**Halifax Road, Penistone
Proposed Site Access Arrangements
Response Report to Stage 1 Road Safety Audit**

December 2020 (Initial Issue)

Prepared on behalf of
**Barratt Homes & David Wilson Homes
Yorkshire West**

Road Safety Audit Stage 1

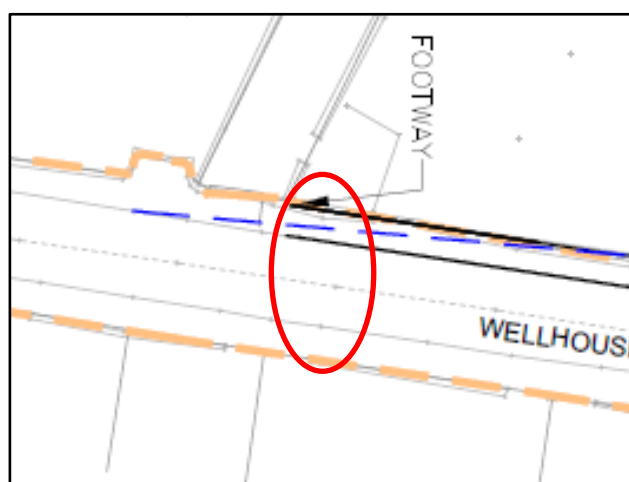
Location – Well House Lane; pedestrian facilities

Summary: Increased risk of pedestrian trips and falls

The current drawings do not show a pedestrian crossing point from the footway serving the new proposed development to the eastern footway. As this is a bus route, this will become a pedestrian desire line and an absence of pedestrian crossing facilities could lead to pedestrians crossing the road at inappropriate places, and / or tripping and falling over full height kerbs. This will be a particular hazard to those with mobility and visual impairments and for those with manual wheelchairs and pushchairs.

Pedestrian crossing facilities should be provided with a dropped kerb and tactile paving across Well House Lane.

RSA Problem	RSA Recommendation	Design Organisation Response	Overseeing Organisation Response	Agreed RSA Action
2.1 Problem Location – Well House Lane; pedestrian facilities Summary – <i>Increased risk of pedestrian trips and falls.</i> Detail – The current drawings do not show a pedestrian crossing point from the footway serving the new proposed development to the eastern footway. As this is a bus route, this will become a pedestrian desire line and an absence of pedestrian crossing facilities could lead to pedestrians crossing the road at inappropriate places, and / or tripping and falling over full height kerbs. This will be a particular hazard to those with mobility and visual impairments and for those with manual wheelchairs and pushchairs.	Pedestrian crossing facilities should be provided with a dropped kerb and tactile paving across Well House Lane.	The RSA recommendation is accepted and pedestrian crossing facilities will be provided on Well House Lane and will be included as part of the detailed access design once public transport provision is finalised for the development.	As Design Organisation response.	To provide pedestrian crossing facilities on Well House Lane to suit likely pedestrian desire lines. Details of the facilities will be included for consideration within a Stage 2 RSA following completion of the detailed design.

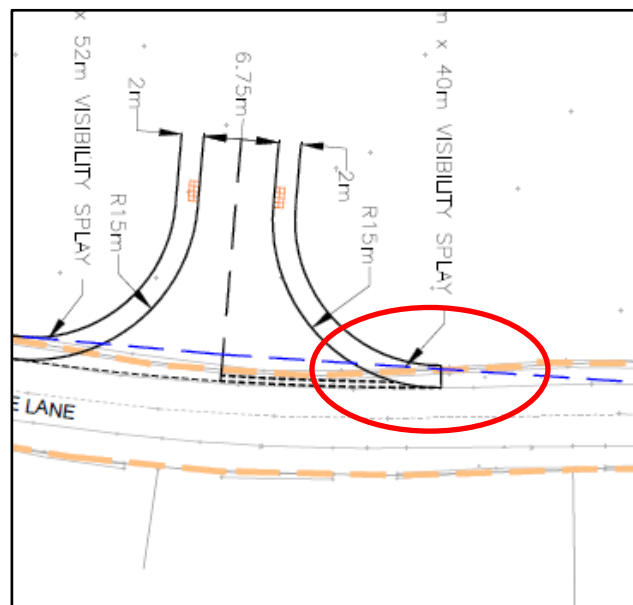
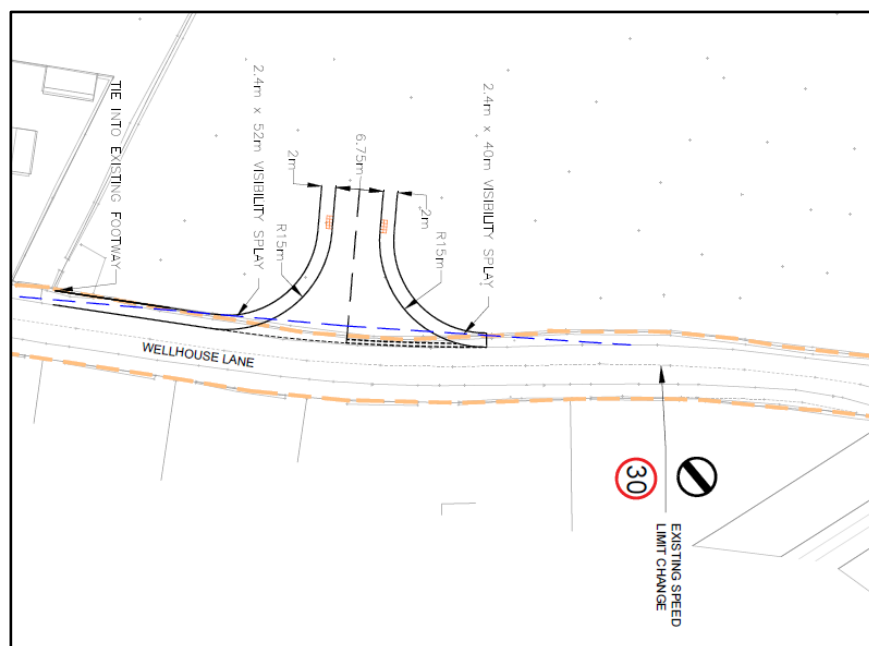
Location – Well House Lane development access; pedestrian crossing

Summary: Increased risk of pedestrian trips / falls / vehicle conflict

The current drawings show the northern footway to be tied into the existing kerb which does not currently have a footway. Errant pedestrians may attempt to follow the kerb line northwards and risk being exposed to moving vehicles within the carriageway particularly those with visual impairments, should any delineation be excluded.

The correct tactile paving / delineation / footway termination point should be installed on the northern footway from the development.

2.2 Problem Location – Well House Lane development access; pedestrian crossing. Summary – <i>Increased risk of pedestrian trips / falls / vehicle conflict.</i> Detail – The current drawings show the northern footway to be tied into the existing kerb which does not currently have a footway. Errant pedestrians may attempt to follow the kerb line northwards and risk being exposed to moving vehicles within the carriageway particularly those with visual impairments, should any delineation be excluded.	The correct tactile paving / delineation / footway termination point should be installed on the northern footway from the development.	The RSA recommendation is accepted and a suitable termination point will be provided.	As Design Organisation response.	To provide a suitable termination point on the northern footway from the development. The detail will be included for consideration within a Stage 2 RSA following completion of the detailed design

20005-GA-01-REV_D

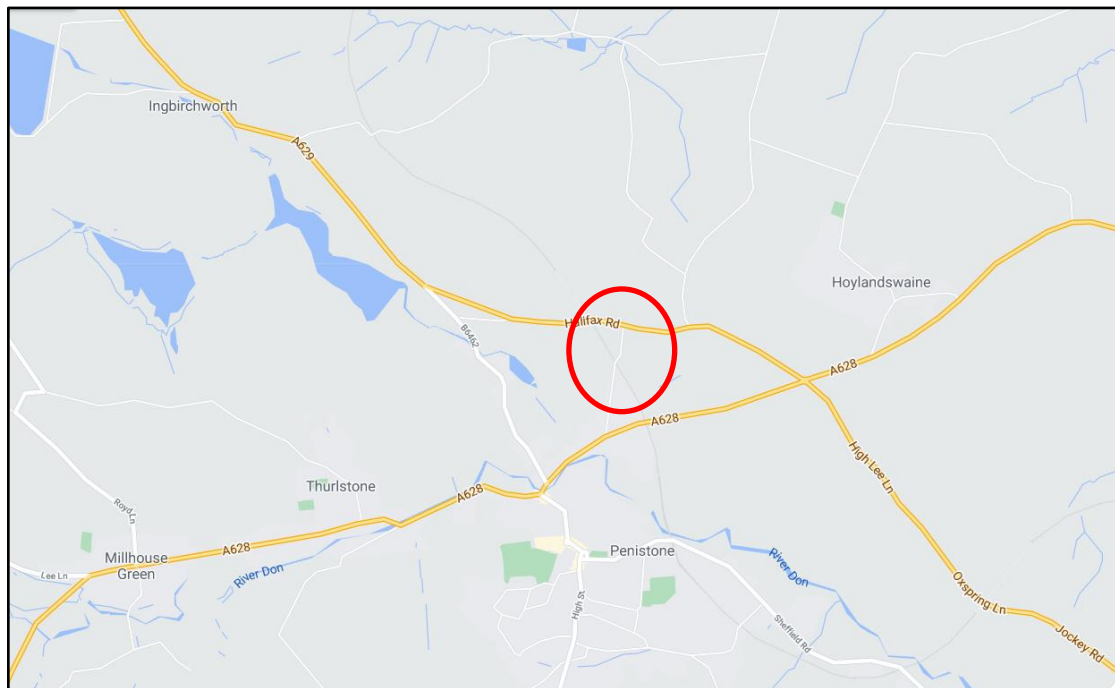
2.4 PROBLEM

Location – A629 Halifax Road; proposed access

Summary: Potential risk of side swipe type collisions

No swept path analysis has been provided for likely vehicle usage at the proposed junction. A lack of suitable geometry at the proposed junction could lead to likely vehicle users turning into or out of the junction into the path of other users or collide with the splitter island. In addition, large vehicles turning right within the right turn lane may swing out unexpectedly into the path of vehicles travelling eastbound.

Swept path analysis should be undertaken for likely vehicle usage at the junction and the geometry adjusted, as necessary. Drawing number 20005/GA/0 Rev A shows the current radii of the junction at 10m, current guidance CD 123 (formerly 42/95) shows a minimum of 15m for rural roads with ghost island layouts. This should be amended for the detailed design.

2.4 Problem Location – Halifax Road; proposed access. Summary – Potential risk of side swipe type collisions. Detail – No swept path analysis has been provided for likely vehicle usage at the proposed junction. A lack of	Swept path analysis should be undertaken for likely vehicle usage at the junction and the geometry adjusted, as necessary. Drawing number	The RSA recommendation is accepted and swept path analysis has been carried out. This has resulted in an amendment to the radii to increase these to 15m in line	As Design Organisation response.	To amend the design to fully accord with DBRB with regard to junction radii (as shown on drawing no. 20005/GA/10 Rev C).

RSA Problem	RSA Recommendation	Design Organisation Response	Overseeing Organisation Response	Agreed RSA Action
suitable geometry at the proposed junction could lead to likely vehicle users turning into or out of the junction into the path of other users or collide with the splitter island. In addition, large vehicles turning right within the right turn lane may swing out unexpectedly into the path of vehicles travelling eastbound.	20005/GA/01 Rev A shows the current radii of the junction at 10m, current guidance CD 123 (formerly 42/95) shows a minimum of 15m for rural roads with ghost island layouts. This should be amended for the detailed design.	with the RSA recommendation. The revised detail is shown on drawing no. 20005/GA/10 Rev C.
